**MS-06 CHANNEL IMPROVEMENTS - TYPICAL SECTION**

SADDLEHORN RANCH - FILING 3 CHANNEL IMPROVEMENT PLANS

SHEET 48 OF 64  
JOB NO. 25142.05

**MS-06 CHANNEL IMPROVEMENTS - TYPICAL SECTION**

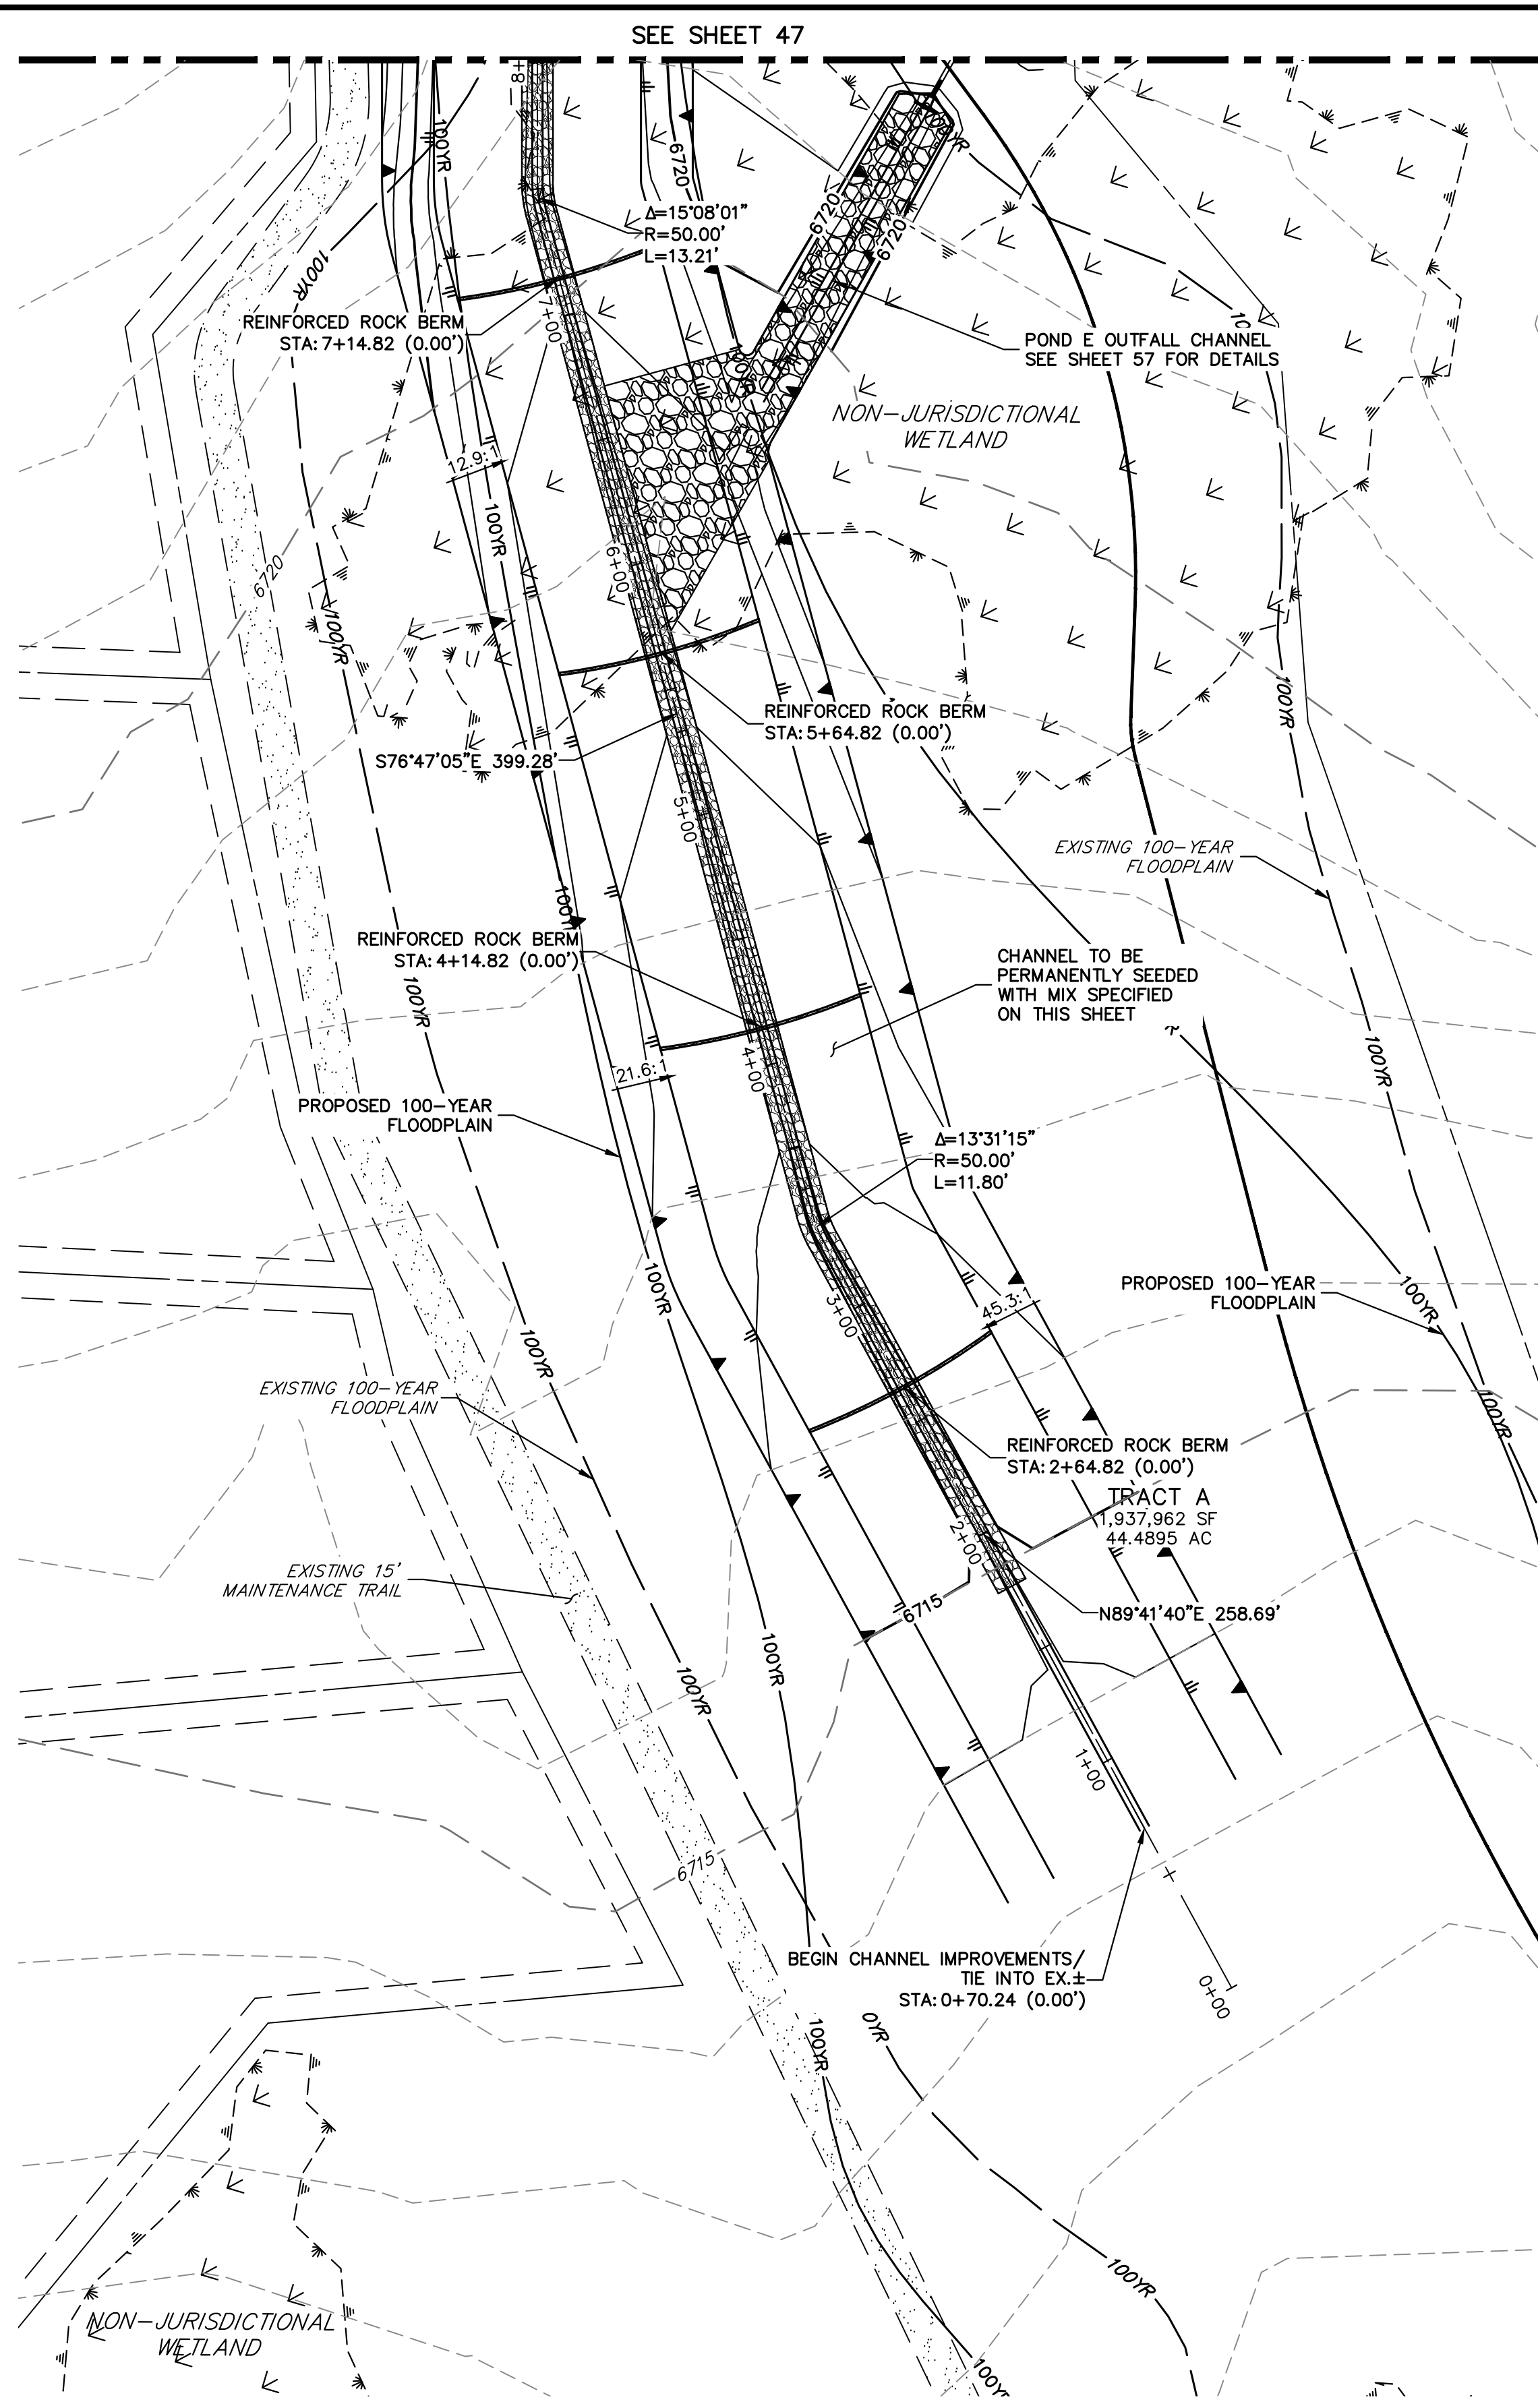
Consider adding a cutoff wall at the full graded width (see FDR sheet)

**JR Response: Cutoff walls have been added to this section along the full graded width.**
